From: Simon Davis
Sent: 17 April 2020 14:26
To: 'Ben Daines' [REDACTED]
[REDACTED]
Subject: RE: BE/137/19/RES

Drawing Title
Detailed Site Plan

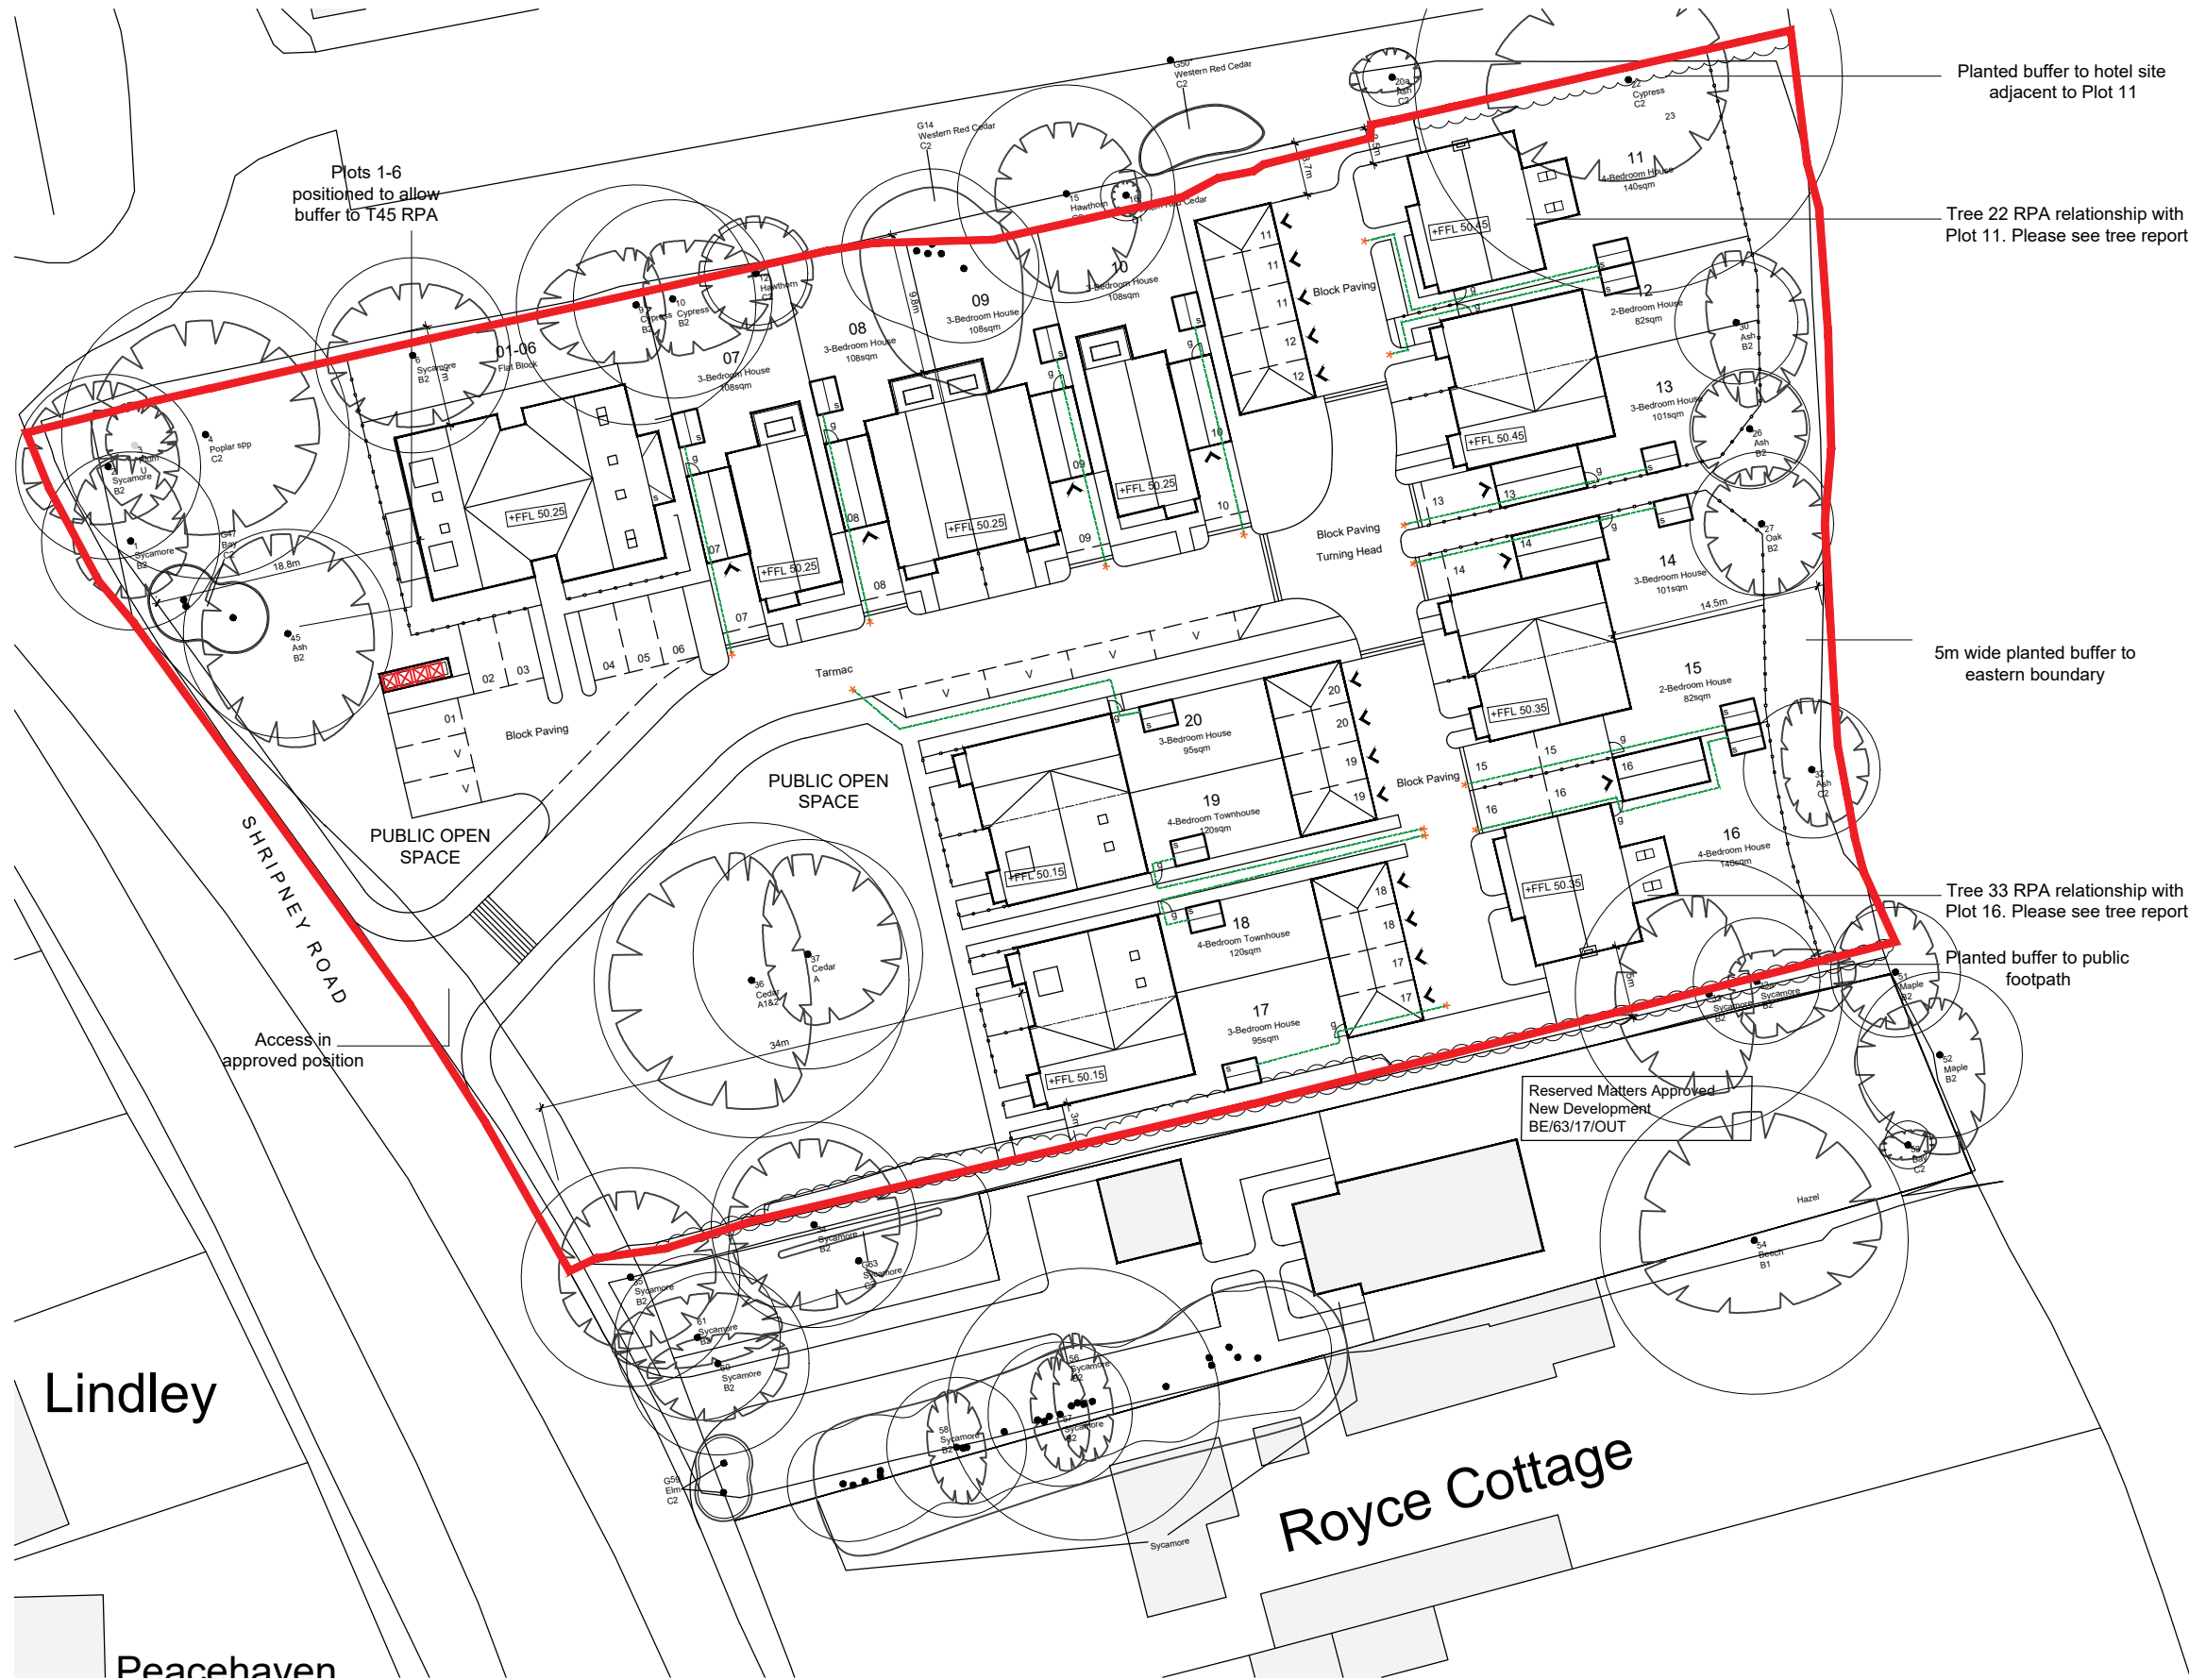
Now that is embarrassing. Yes sorry you are right they are all car ports not garages, in which case, you now exceed the parking requirements.

On parking, I calculate the new requirement to be 46 spaces total (42 + 4 visitor) and see that you propose 43.5 (with the half a result of garages treated as 0.5 a space each). I note that you have removed the pathway between 18 & 19 and gained an extra visitor space which is good. I would suggest that you do incorporate secure rear doors on the car ports for plots 17-20.

Please find attached an amended site layout which addresses the following issues:

You will note that we have two additional parking spaces and have changed dwellings 18 and 19 from 4 bed dwellings to 3 bed dwellings. Please confirm that this now meets the Council's parking standards and we will submit the amended plans and elevations for these units.

Having regard to the comments raised by WSCC regarding the visitor spaces to the north of Unit 20, we do not really consider this to be an issue and parking restrictions would seem heavy handed. Surely there are significant incentives for the occupiers of Units 17 to 20 to park their cars within the car ports at the rear of the properties i.e. protection from the elements and other cars which may be parking in these spaces. The distance from the car ports to the front doors of the dwellings is certainly not excessive but we would be willing to add doors in the western elevations of the car ports to allow people to access their properties from the rear if that would help address the issue.
